CLIVE JONES ON BEHALF OF WOKINGHAM LIBERAL DEMOCRATS

WRITTEN REPRESENTATION

HIGHWAYS ENGLAND'S RESPONSE

Project	SMART MOTORWAYS PROGRAMME
	M4 JUNCTIONS 3-12
Drawing title	ENVIRONMENTAL MASTERPLAN
	REGULATION 4(2)(e)
	SHEET 13 OF 61
	CUTBUSH LANE OVERBRIDGE

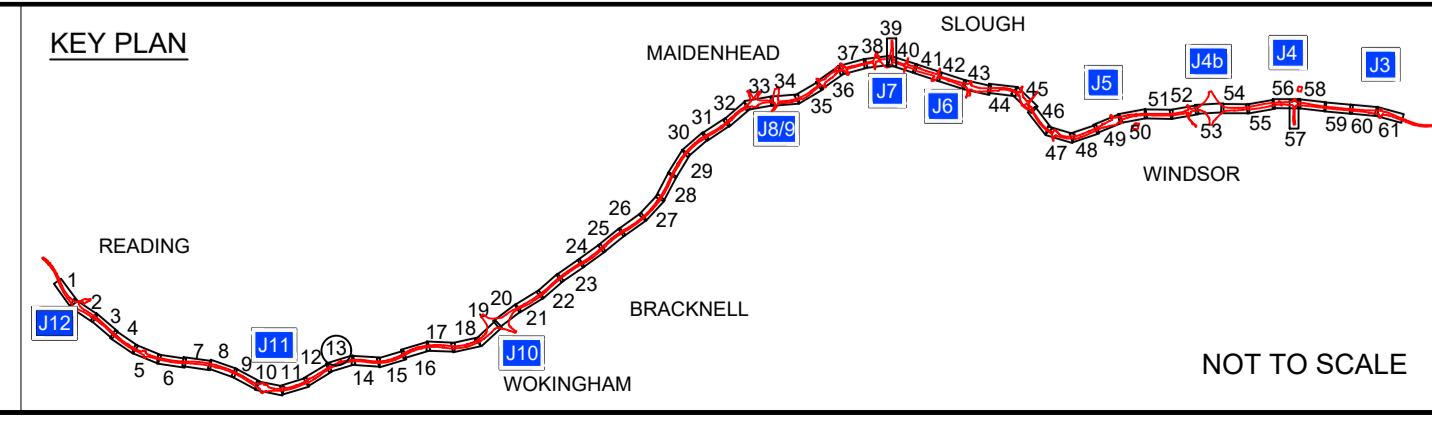
3. *This is a 3-stage process involving a noise reduction test, a cost/benefit analysis, with 'professional judgement' thrown in to allow flexibility. The noise reduction criteria and the cost/benefit analysis hurdles must both be met for new or replacement barriers to be recommended. Between junctions 10 and 11 of the M4 there are very few replacement barriers. As I was able to point out on the accompanied site visits there are some fences which are there to keep people away from the motorway. Its somewhat disingenuous of Highways England to call them current barriers. I am thinking particularly of the barriers around the end of the Cutbush Lane area.*

- 17.2 Highways England acknowledges the remainder of the comments made by Mr Jones relating to noise and air quality, but believes that all matters raised have been addressed in previous responses by Highways England to the Examination. The comments on noise and air quality were dealt with in detail in sections 3 and 5 of the response to Mr Jones Deadline IV submission (REP5-003) and in the written summary of the Issue Specific Hearing related to Environment – Noise (paragraphs 16 to 33) and Air Quality (paragraph 17 to question E1 question 4.6.8) issued at Deadline VII.

Project	SMART MOTORWAYS PROGRAMME
	M4 JUNCTIONS 3-12
Drawing title	ENVIRONMENTAL MASTERPLAN
	REGULATION 4(2)(e)
	SHEET 14 OF 61
	LOWER EARLEY

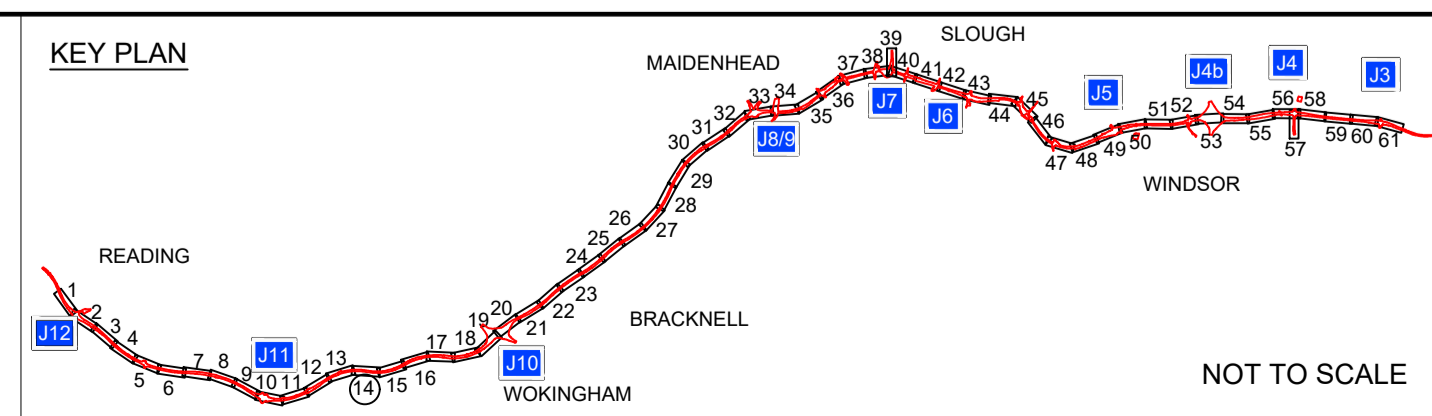
4. *If we understand the data correctly, Lower Earley (EM8) passes the cost/benefit test at all barrier heights up to 4m, but passes the noise test only with 2.5 m high barriers. The tables show that the 2.5 m high barrier reduces noise by 4.7 dB (easily passing the test) but reduces noise by only 0.9 dB at the 3.0m barrier height (thus failing the test for this height by just 0.1 db.). Thus a 2.5m high barrier is recommended.*

8. *Moreover, if for some reason the noise reduction test is retained, what is the basis for the criteria used in the assessment? For example, why was 1.0 dB chosen as the criterion for an increase of 0.5 m increase in barrier height rather than 1.0 plus or minus 0.1dB? This minor change would have given Lower Earley a 3.0 m barrier rather than a 2.5 m barrier. The chosen criteria for success or failure seems arbitrary when compared with the well documented science based approach used in the cost/benefit analysis.*
